Our Ref: F2019/00456

Re: SSD 9606 - UNSW Building D14 Redevelopment

Thank you for the opportunity to comment on the Response to Submissions (RtS) Report prepared by Ethos Urban on behalf of the University of New South Wales (UNSW) for the State Significant Development Application SSD 9606 – UNSW Building D14.

Cross section showing relationship of the proposed Building D14 north-eastern terraces and the White House.

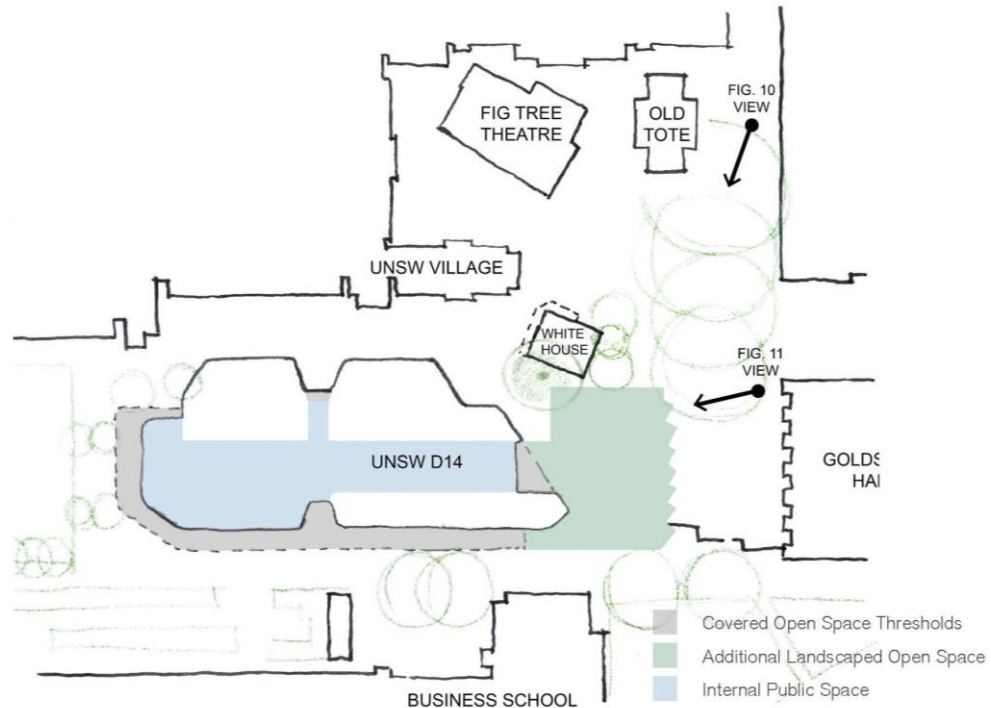
The two sections provided by the proponent indicate that the retail and student led spaces in the new D14 Building will be on the same ground floor level as that of the existing White House heritage item. Council also notes that the proposed bleachers have been reconfigured so that they do not obstruct ground level entry into the Retail shop 2. Council supports these clarifications but would request that consideration be given to the following suggestions so as to enhance the spatial relationship between the Heritage Conservation Area and the new Building D14:

- The role, configuration and extent of the proposed bleachers be carefully considered so as not to obstruct the curtilage and useable open space around the White House.
- Conditions be applied to any development consent requiring suitable strategies/programs in the new Building D14 that would activate the space between the HCA and the new retail facilities and, importantly, to promote future adaptive reuses for the White House, the Fig Tree Theatre and the Old Tote as well as the shared heritage conservation area surrounding these items.
- Conditions be applied to any development consent to enhance pedestrian access and permeability between the HCA and the ground and upper levels of the new building
- Conditions be applied to any development consent requiring additional/augmented measures to soften/mask the impact of the new D14 tower directly adjoining the HCA and White Hall.”
